Please ask for: Mrs D Johnson
Email: daun.johnson@arun.gov.uk
Telephone: 01903 737762
Our Ref: BR/298/20/PL
Your Ref:
Date: 21st December 2020

Application for Planning Permission

Development: New 2 storey extension on first floor with loft floor including 8 (4 front & 4 rear) dormer windows), first floor rear extension (mansard floor) with 8 No roof windows, alterations to ground floor shopfront and new access to upper floor into use for 10 residential units (5 No 1-bed & 5 No 2-bed) (resubmission following BR/196/20/PL). This application may affect the setting of a listed building & the site is in CIL Zone 4 (Zero Rated) as flats.

Location: 25 Sudley Road Bognor Regis PO21 1EW

PROPOSED
- GROUND FLOOR PLAN

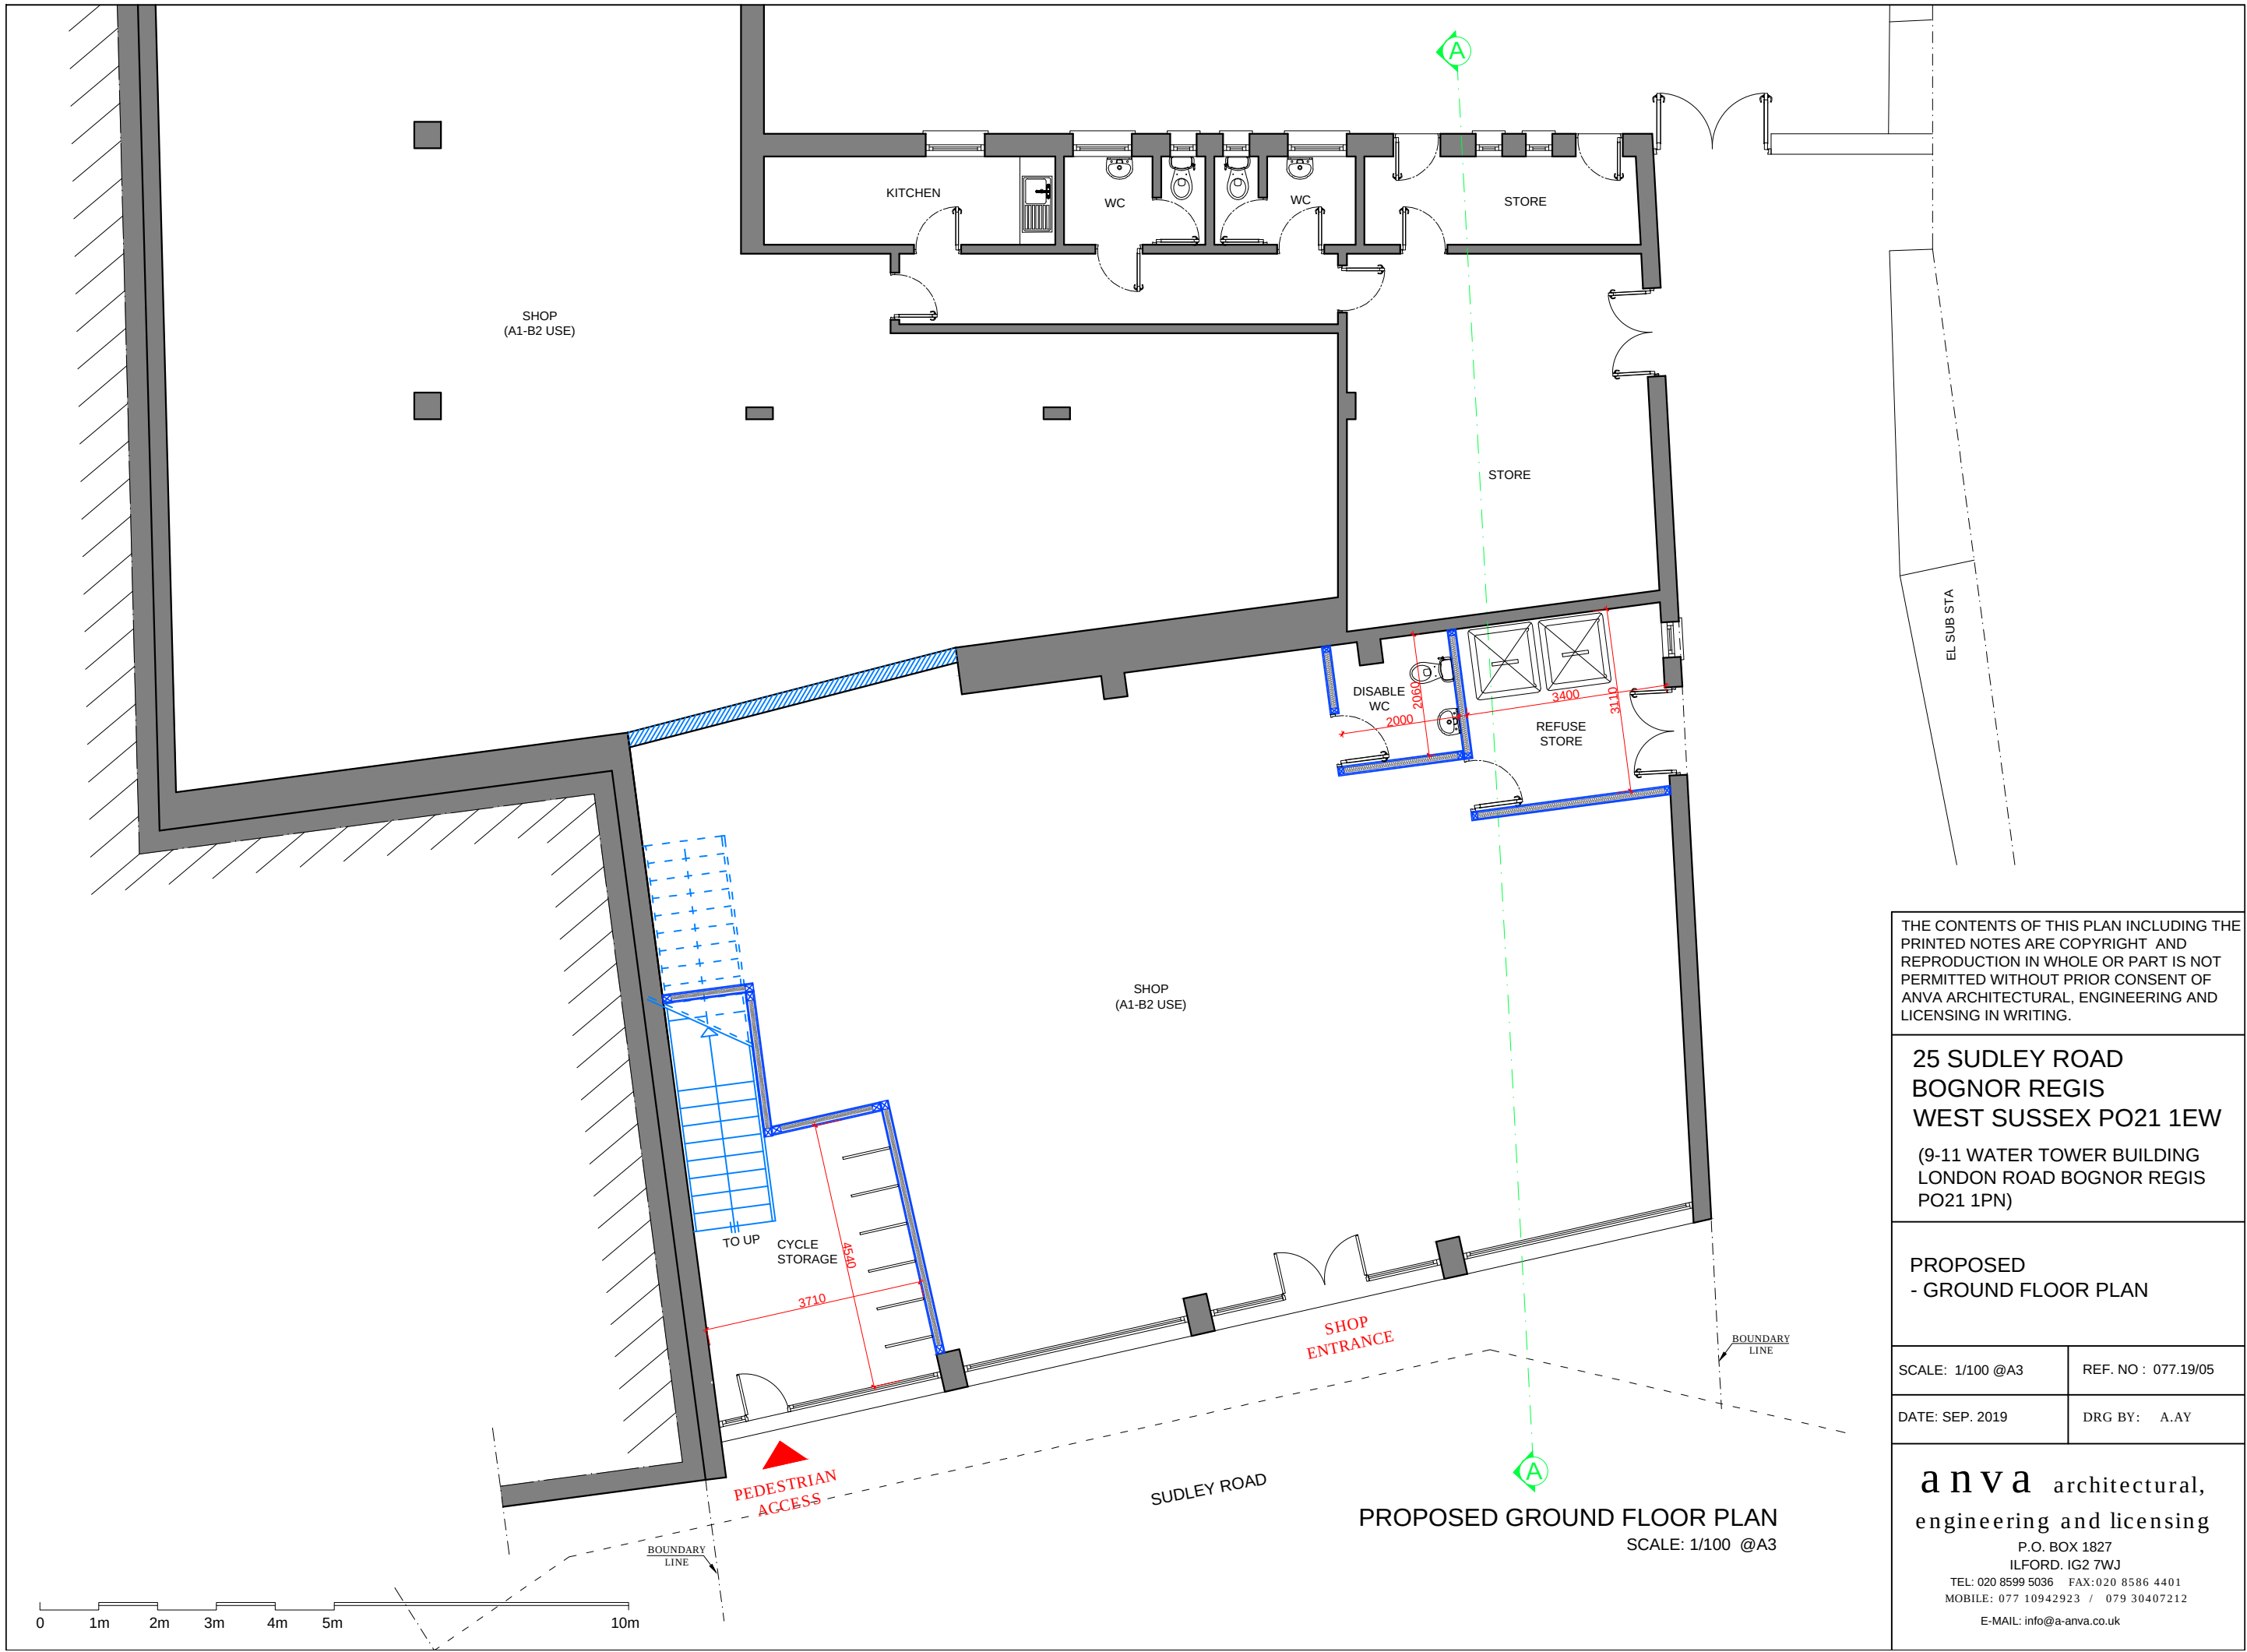
The proposed ground floor plan and side elevation do not accord. Please amend accordingly.
